Rezoning Transportation Analysis

Petition Number: 2023-067

Date	Description
8-24-23	First Review (NK)
9-20-23	Second Review (NK)

TECHNICAL DATA SHEET

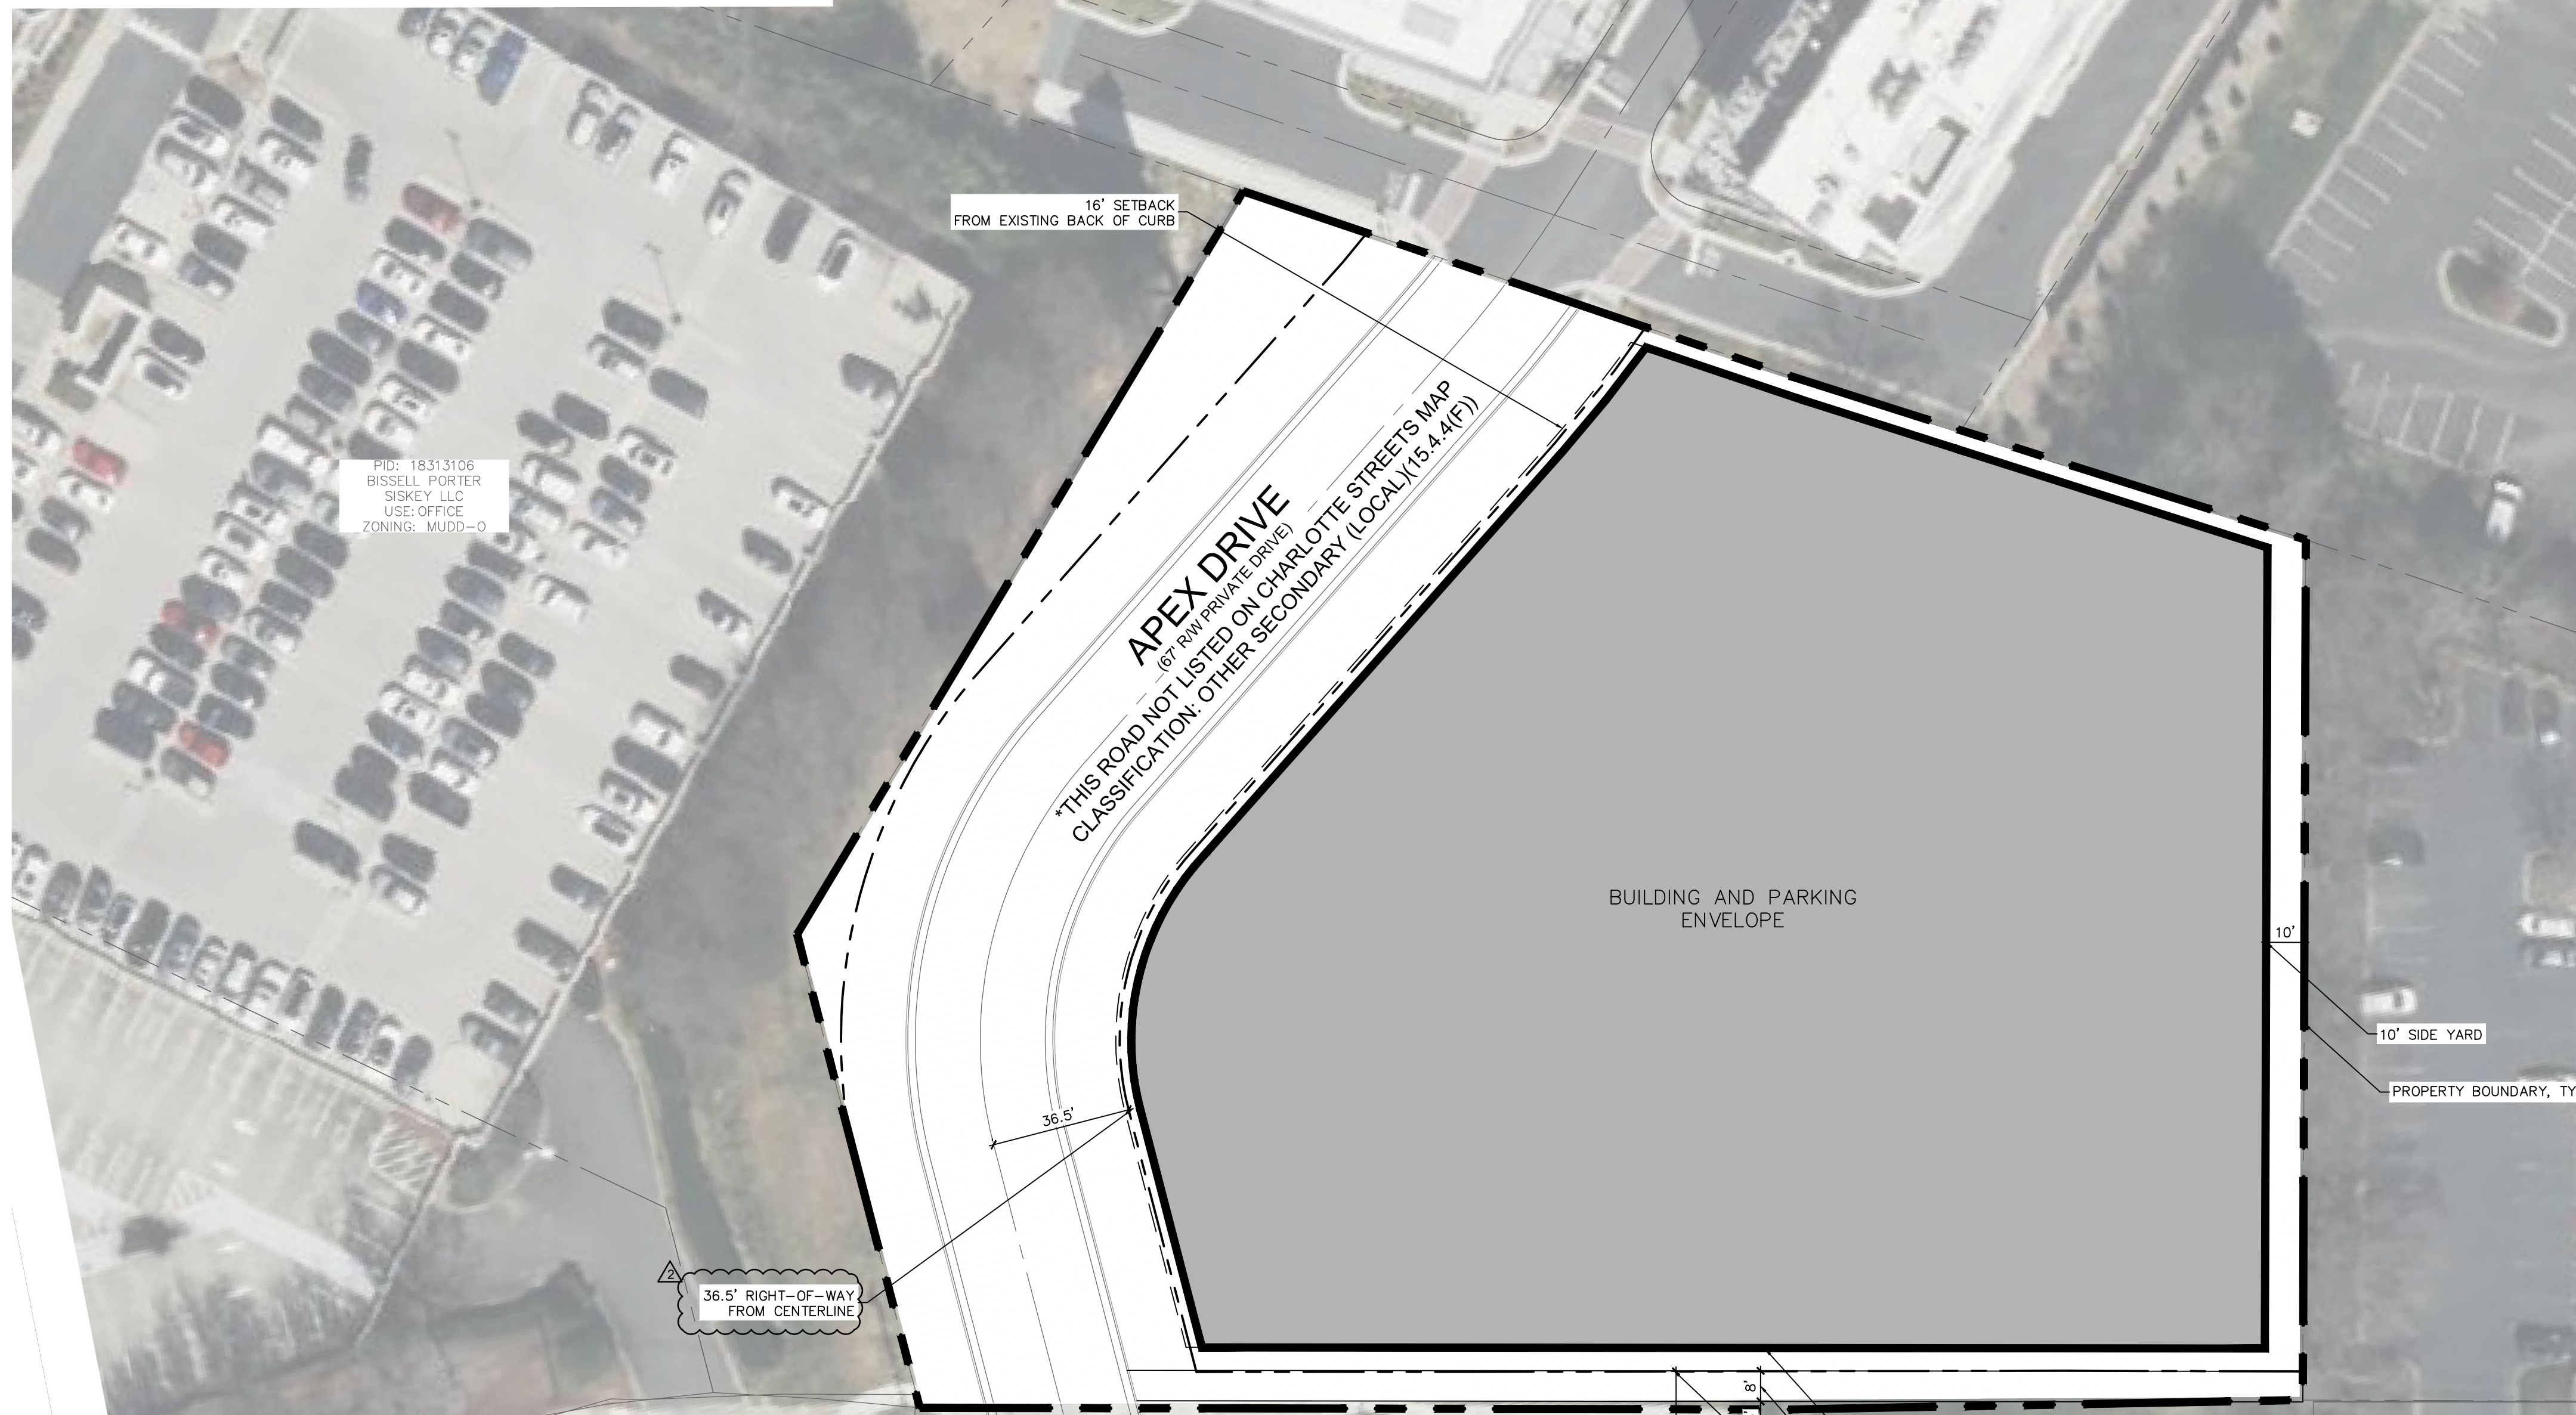
~~Coltsgate Road Future back of curb is in its existing location.~~

~~Label and dimension the curb and gutter from the centerline for each road on the site plan.~~

~~3. Revise site plan and conditional note(s) to commit to dedicate 36' 6" right-of-way from the road centerline. The site plan shall label and dimension the right-of-way from the road centerline.~~
